**Consultation Response from KC,
Lead Local Flood Authority**

2024/92806 Land at, Penistone Road, Fenay Bridge, Huddersfield, HD8 0AW

Discharge of details reserved by conditions 20 (surface water discharge), 21 (flood routeing) and 31 (grass-crete and batter maintenance) of previous permission 2022/93154 for erection of 68 dwellings with associated access, parking, open space, landscaping and infrastructure works (including installation of surface water attenuation tank)

Date Responded: 17th April 2025

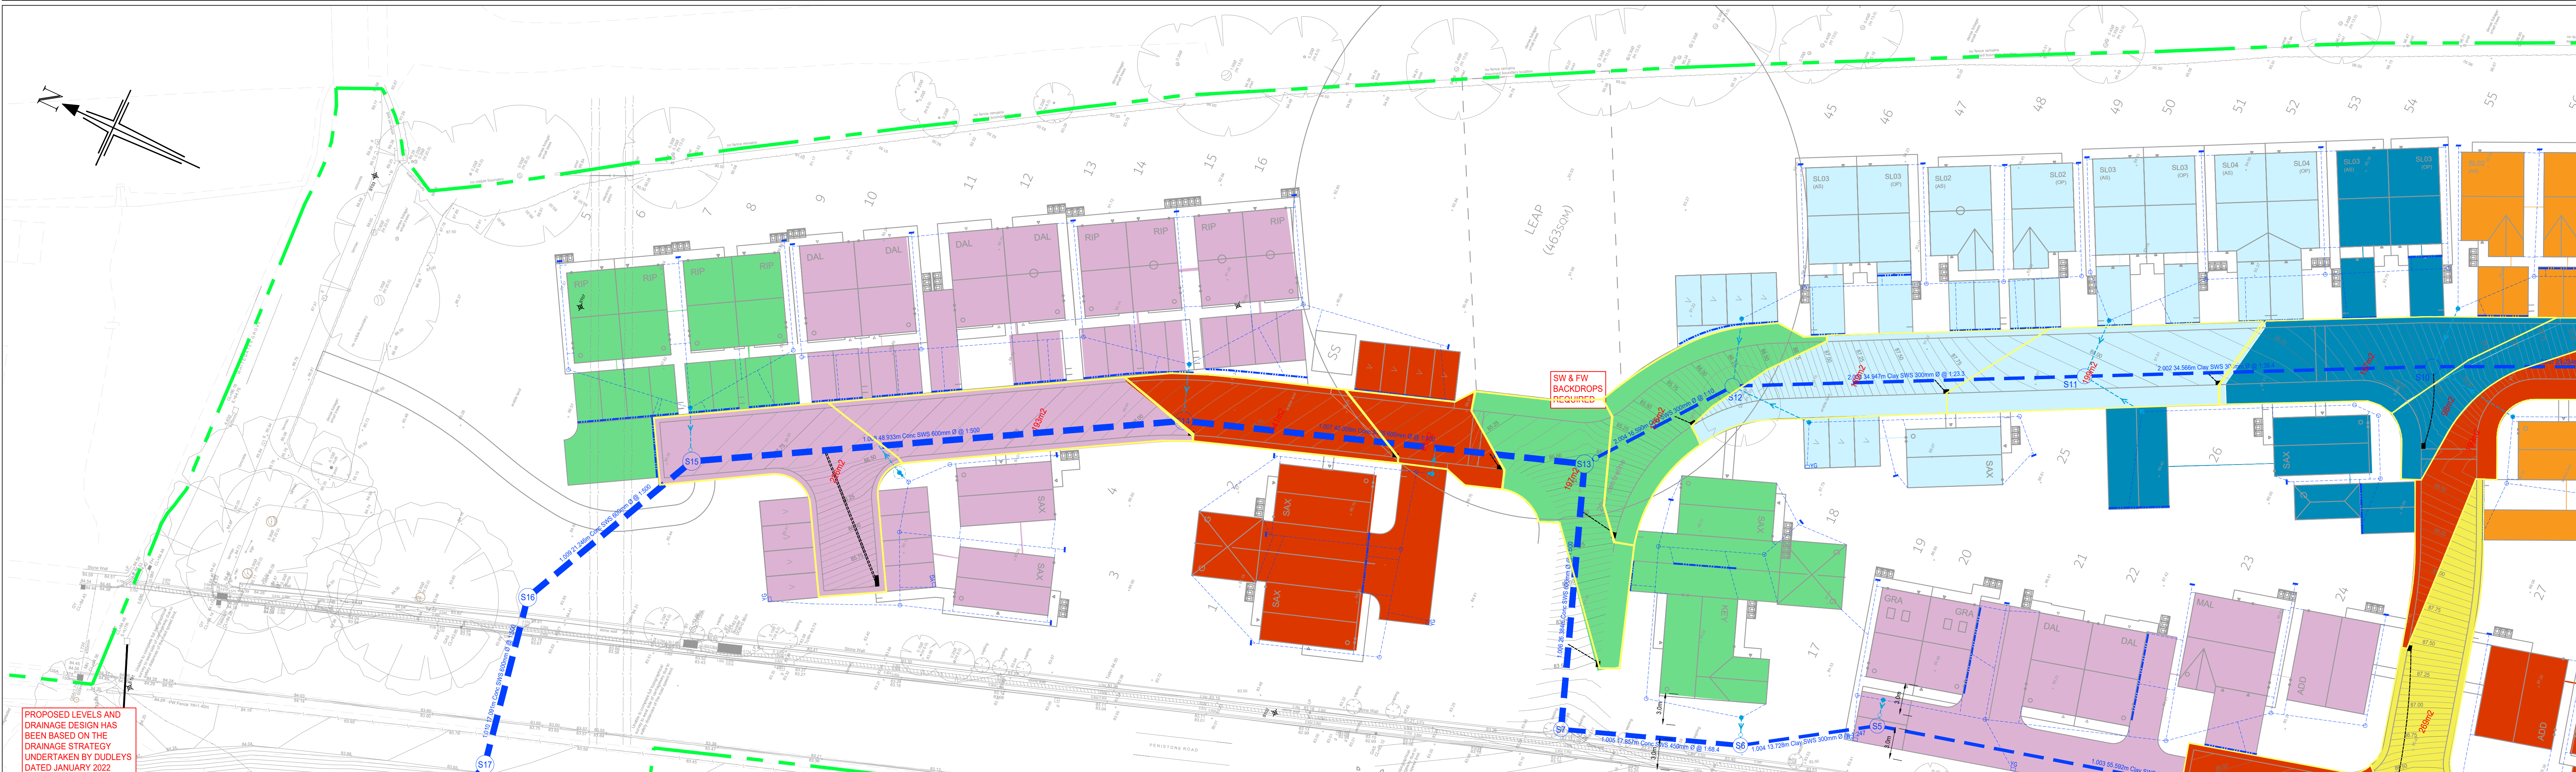
However, there are multiple discrepancies between the measured hard standing area noted on an impermeable area drawing and those listed in the hydraulic design model.

In addition to the above, the impermeable area drawing is erroneous. As an example, around the green shaded area for road network and plots 17 and 18. Both the key and the hydraulic model show no hardstanding contributing to 1.005 (S6 to S7). However, the drawing showing private drainage layout clearly shows the majority of the plot's area draining to this very leg. Both plots are coloured green, but part is connected to 1.004 (S5-S6) and the roads of the same colour drain to 3 different legs of sewer not 1.

A clear check of all drainage should be made before resubmitting new impermeable area plans with key and update hydraulic modelling.
